TREES & CONSTRUCTION MEMO

To: Paul Bosveld
From: Bob Layton
CC: Heather Crain, Matt Wittman
Date: March 31, 2022; Updated August 20, 2022
Re: Tree Protection at 7345 SE 38th Street, Project 2110-193

TREE RETENTION PLAN

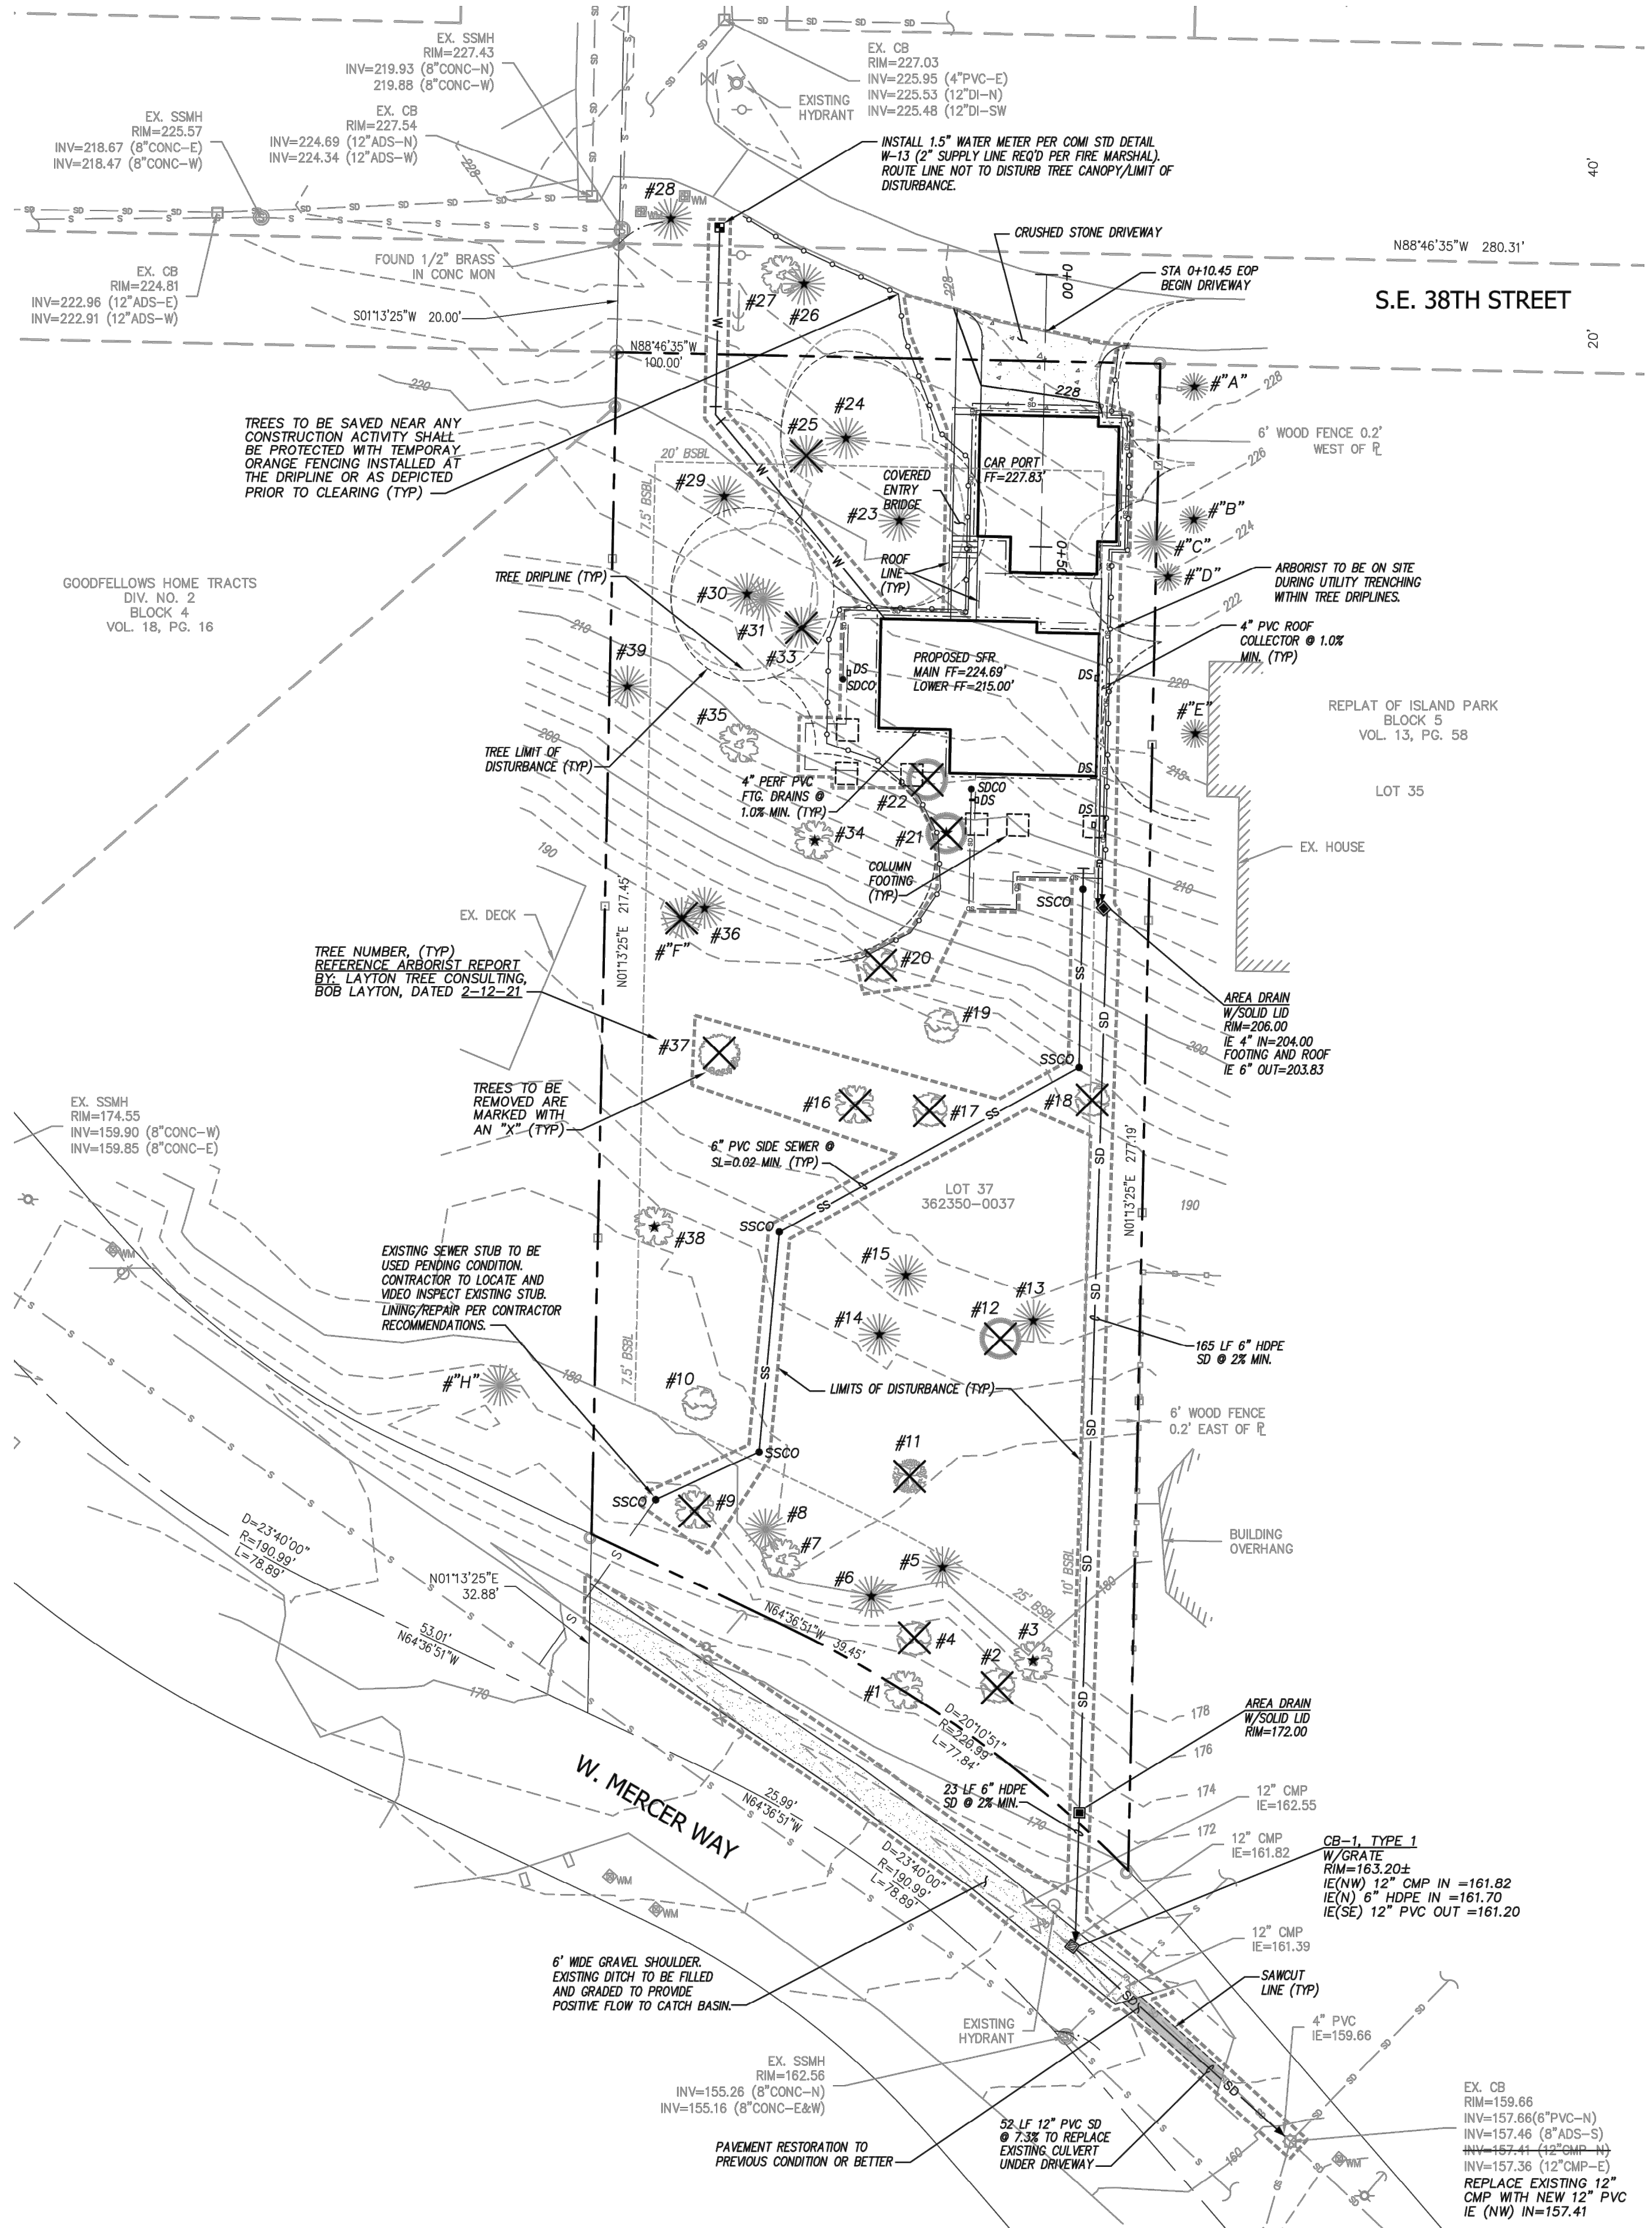
Trees requiring the most attention include Tree #23 and #34, and neighboring Trees B, C, D and E. These are closest to the proposed site work.

The sewer utility has been designed to avoid the driplines of adjacent trees. The storm drain utility on the south perimeter shall be moved closer to the property line to the farthest extent allowable to reduce the impact to Tree #13 and Tree #3. See the attached copy of the site plan. Slightly move trench north away from Tree #15. The majority of trenching can be accomplished with a tracked mini-excavator. Air-excavate adjacent to Tree #13 if access available or hand-excavate to preserve any roots greater than 2-inches in diameter.

Given the number of exceptional trees to be retained within the vicinity of the water line utility, it is not possible to stay at least 12-feet away from all exceptional trees. The location of the trench will ultimately be field-located to be as far from exceptional trees as possible. The entire length of the water line trench will be air-excavated. All roots greater than 2-inches in diameter will be preserved and the utility/pipe routed beneath them. The trench location on the

Another trench was air-excavated adjacent to the east property line at the proposed excavation extents. A cluster of +/- 5 structural roots exist directly west of Tree B. See the attached map. In order to protect roots, the proposed footing northwest of Tree D will be omitted and a cantilever system will be used to support the floating garage floor.

The two closest footings have been omitted from the plans allowing for 5-feet of clearance adjacent to Tree #23.

enlarged excavation
plan

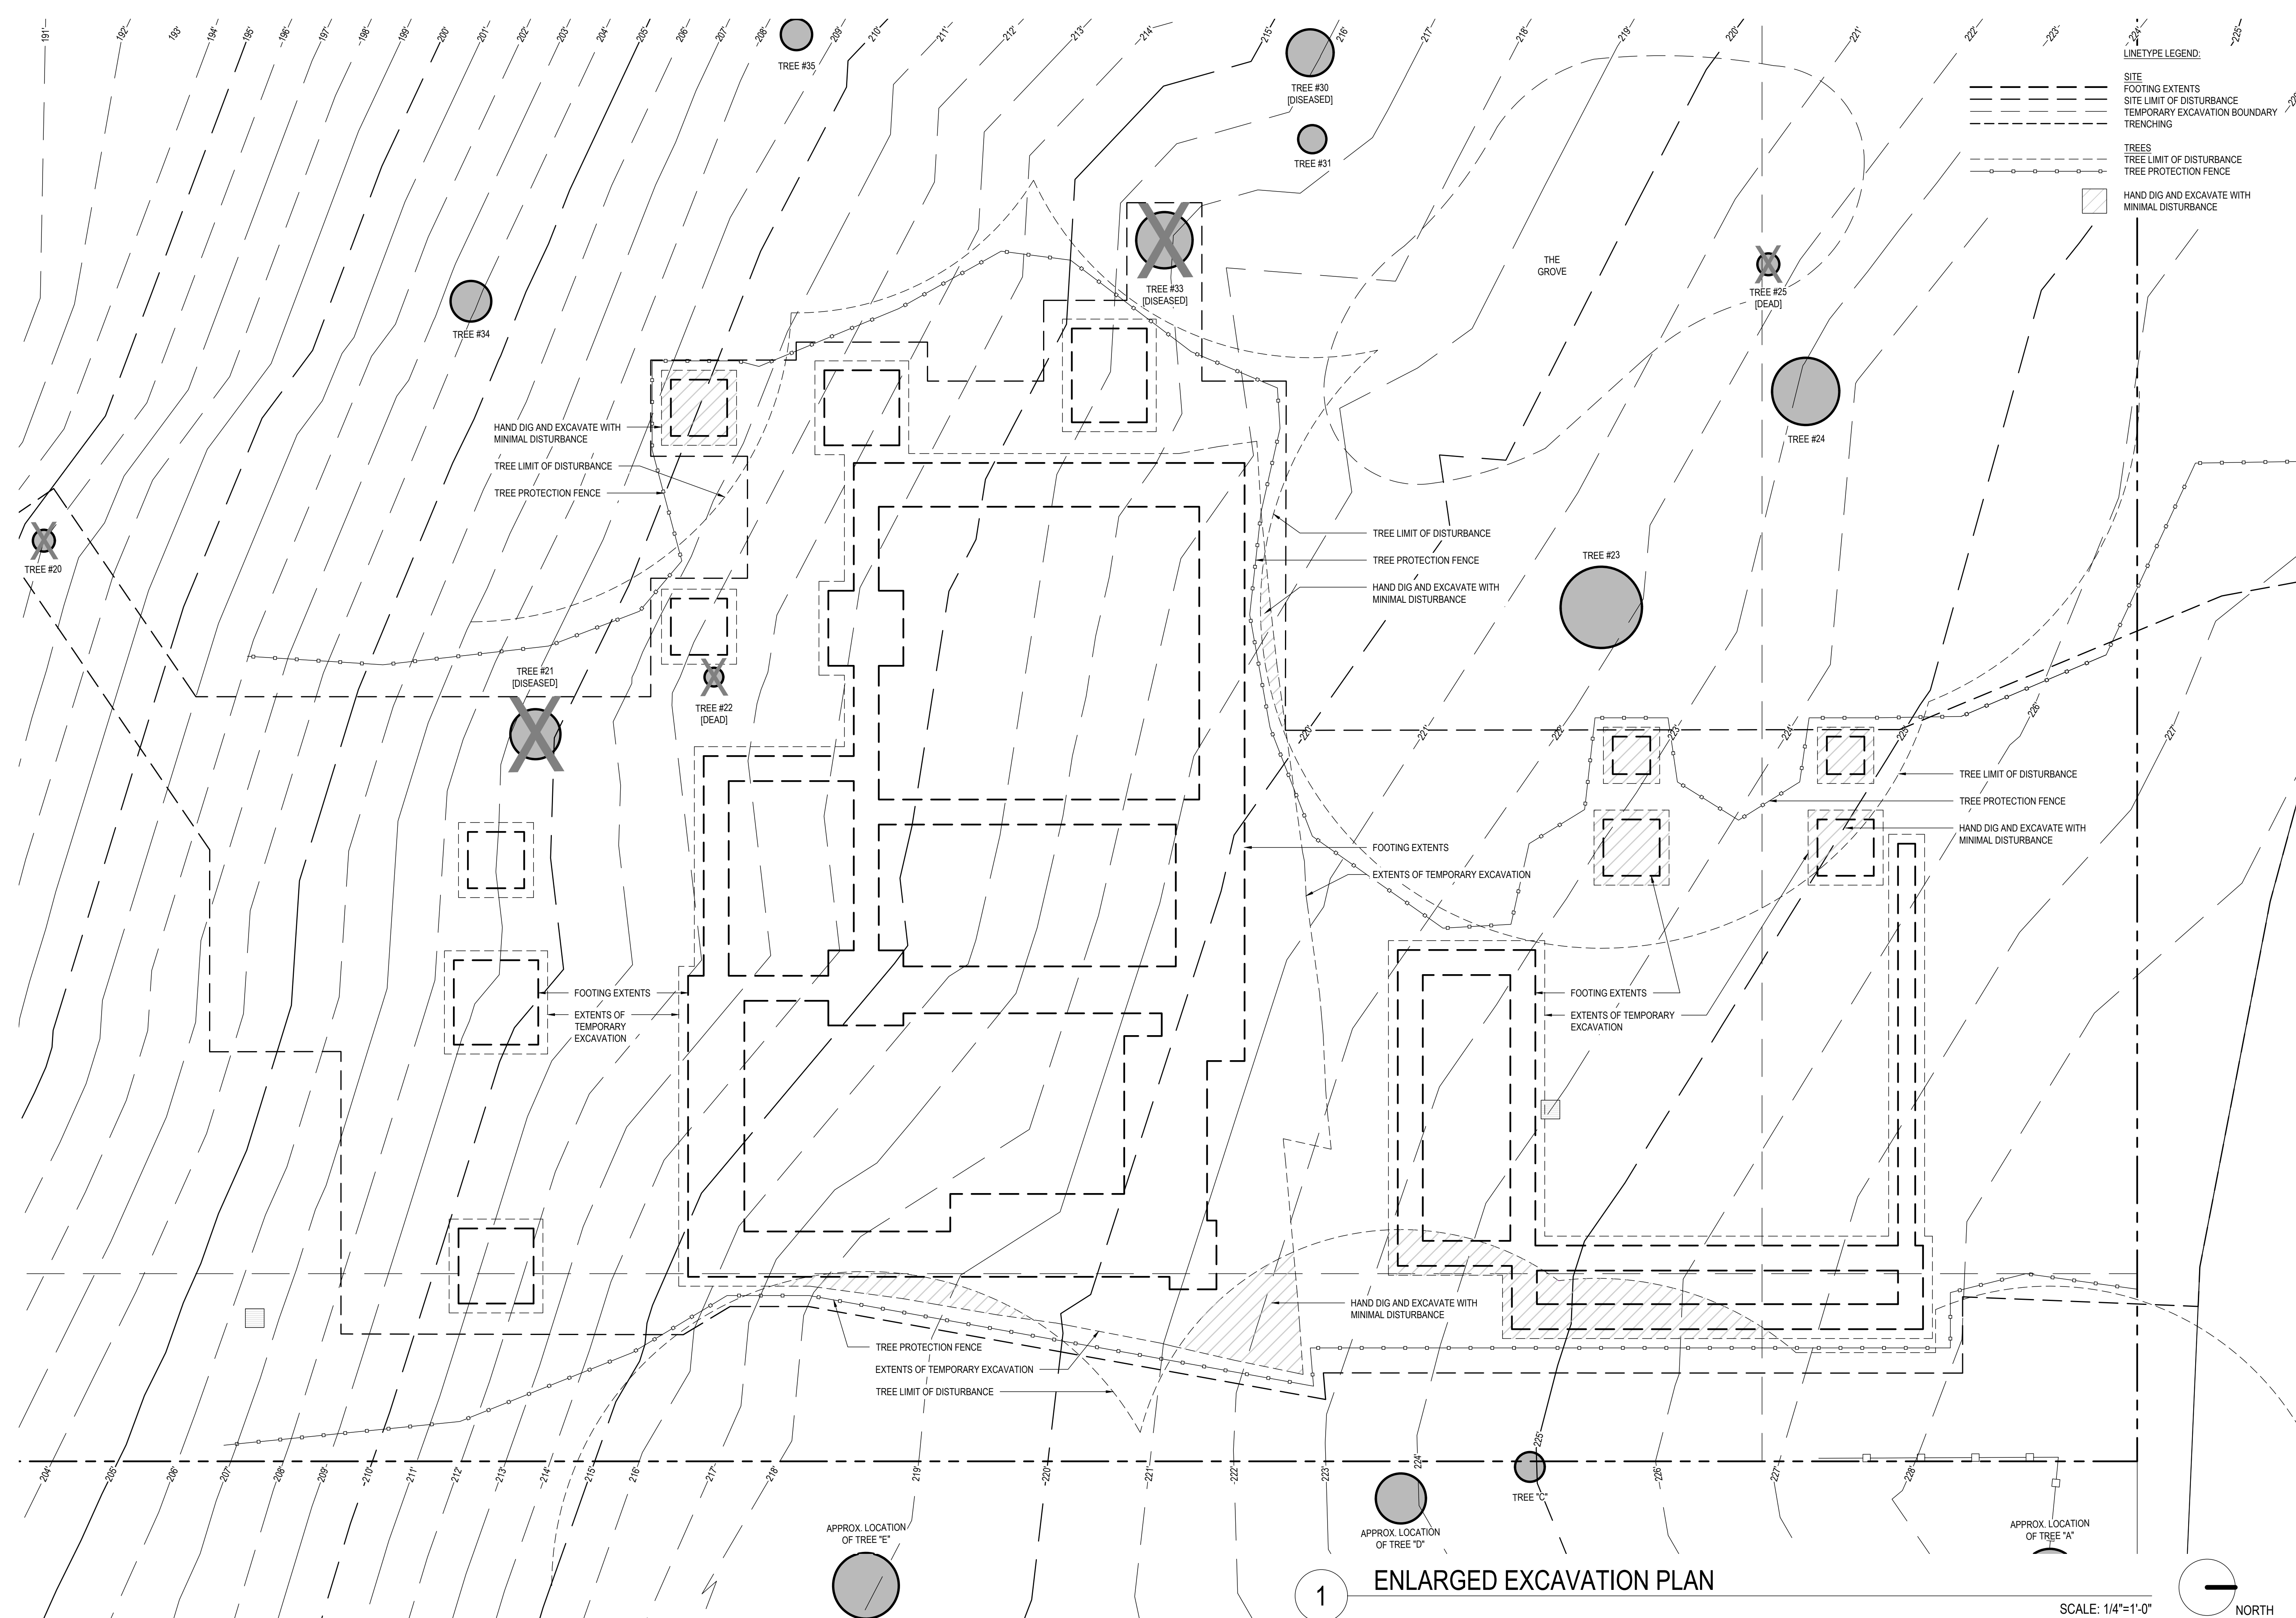
Excavation for the house foundation which lies at the LOD of Tree E will be done with a mini-excavator under the direction of the project arborist. Soils will be gradually cut in small increments and pulled back away from the tree. Any encountered roots will be exposed by hand-digging and pruned back to sound tissue. Over-excavation will be minimized and not exceed 2-feet from the face of the foundation.

All concrete footing locations will be hand-excavated and sited to avoid existing roots that have been exposed by air-excavation or encountered during hand-digging. All preparation work to be done by hand-labor. Concrete will be poured via a chute extending from a truck parked within the confined limits of the new proposed driveway. All concrete needed for this project will be delivered/poured in the same manner.
